### **RE: Boundary Line Adjustment (BL-25-00013) – Deemed Incomplete – Request for Additional Information**

Kittitas County Community Development Services (CDS) received your Boundary Line Adjustment application (BL-25-00013 DCYF) on September 23, 2025, for Parcels 085134 and 295134. Staff has reviewed your application and determined that more information is needed before this application can be processed any further. As such, Kittitas County declares your application **incomplete** as of September 26, 2025.

RECORD OF SURVEY

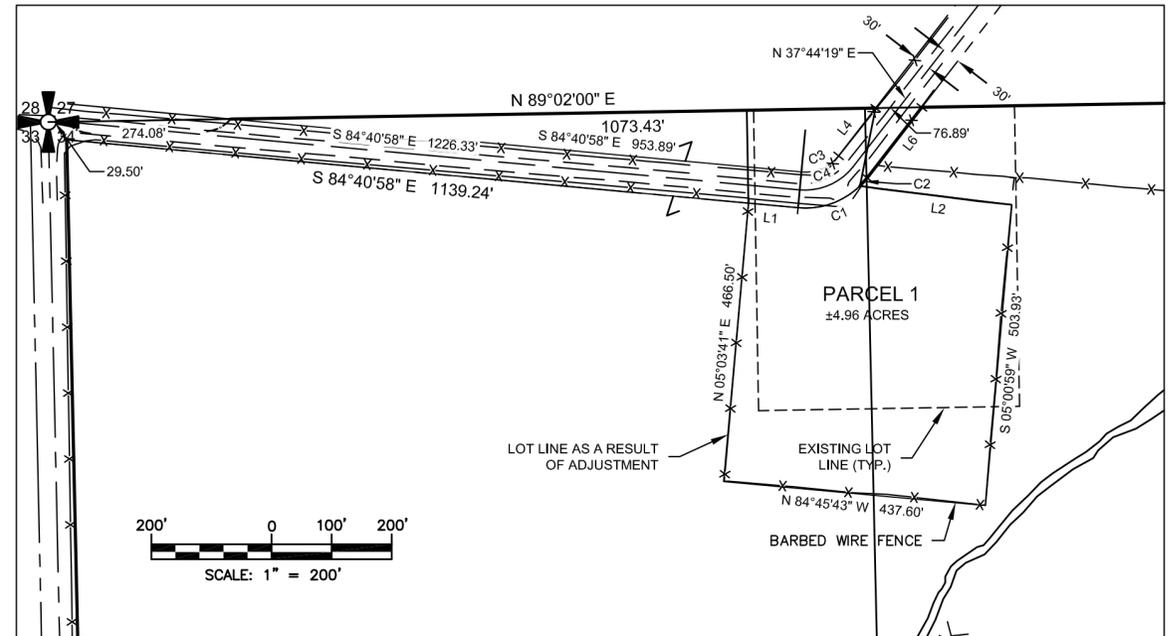
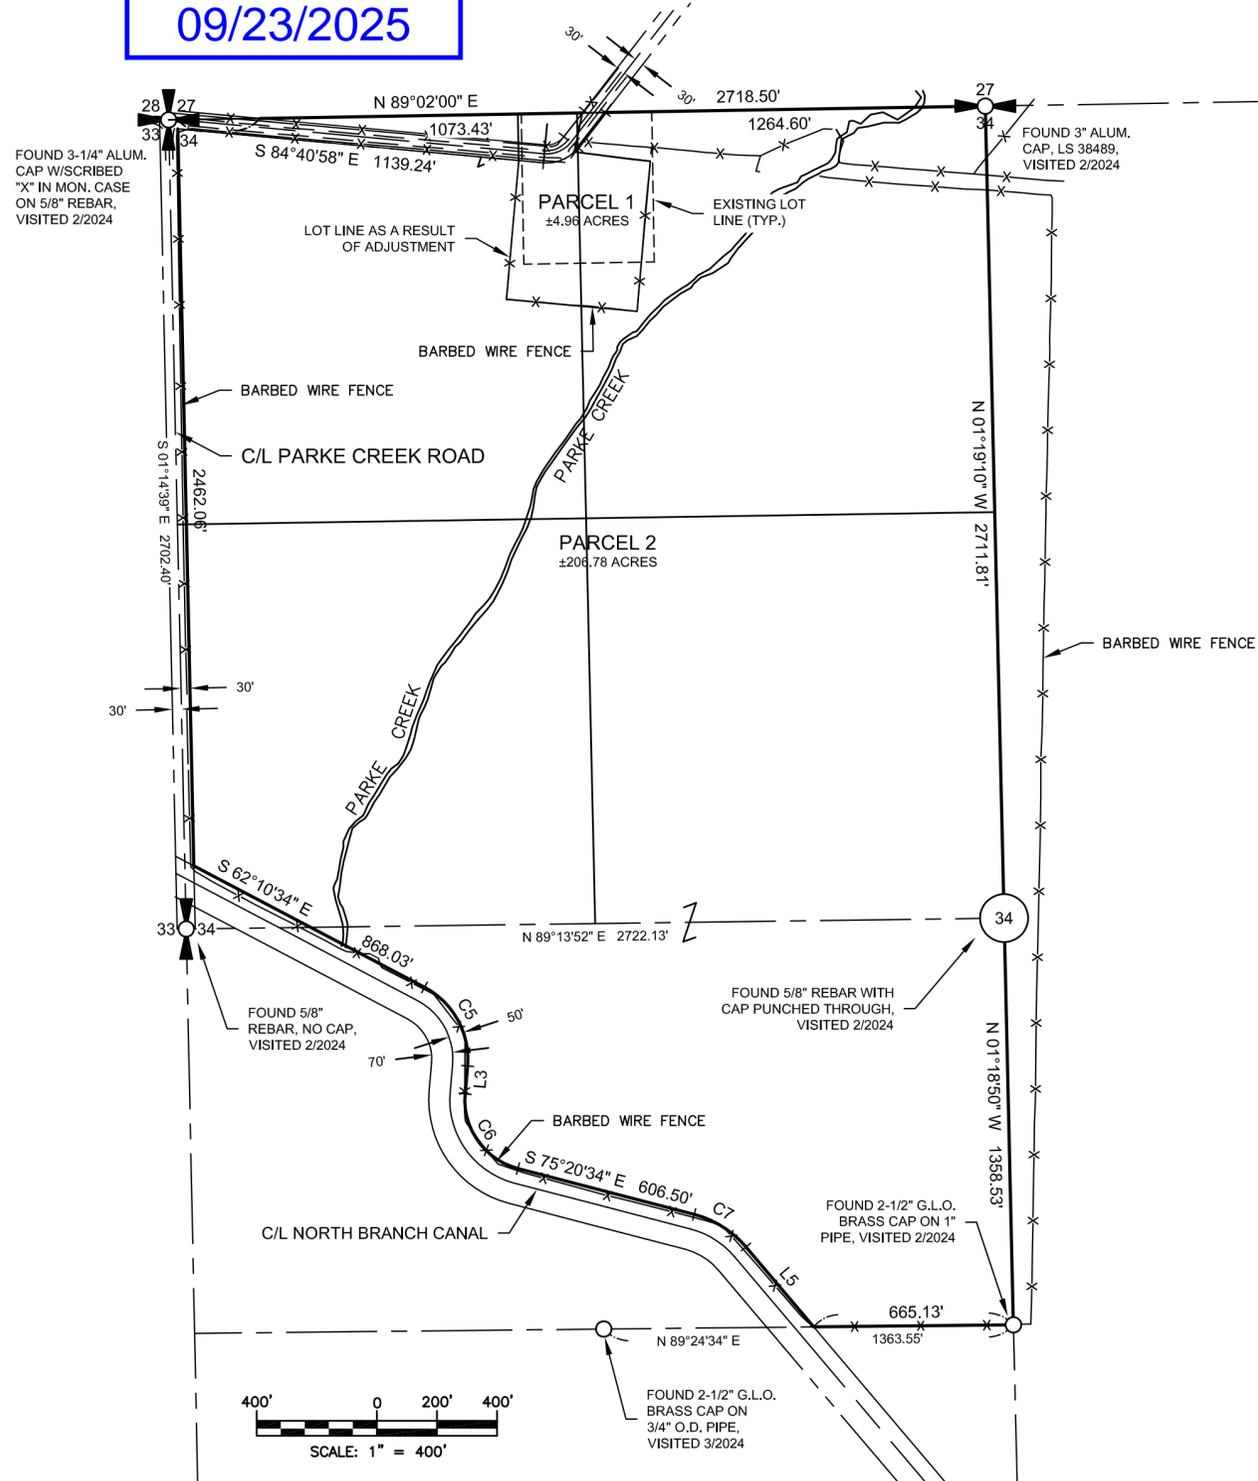
1. Please provide an updated site plan showing all existing on-site structures and their respective distances to all proposed lot lines. This is necessary to ensure lot line setbacks are being met. In addition, there are several mapped fish-bearing streams on these parcels that are not reflected on the submitted survey map. Furthermore, the project narrative lists a well and septic system existing on-site that are not shown on the submitted survey map. All of these elements are required for all Boundary Line Adjustment applications per Kittitas County Code 16.10.020.
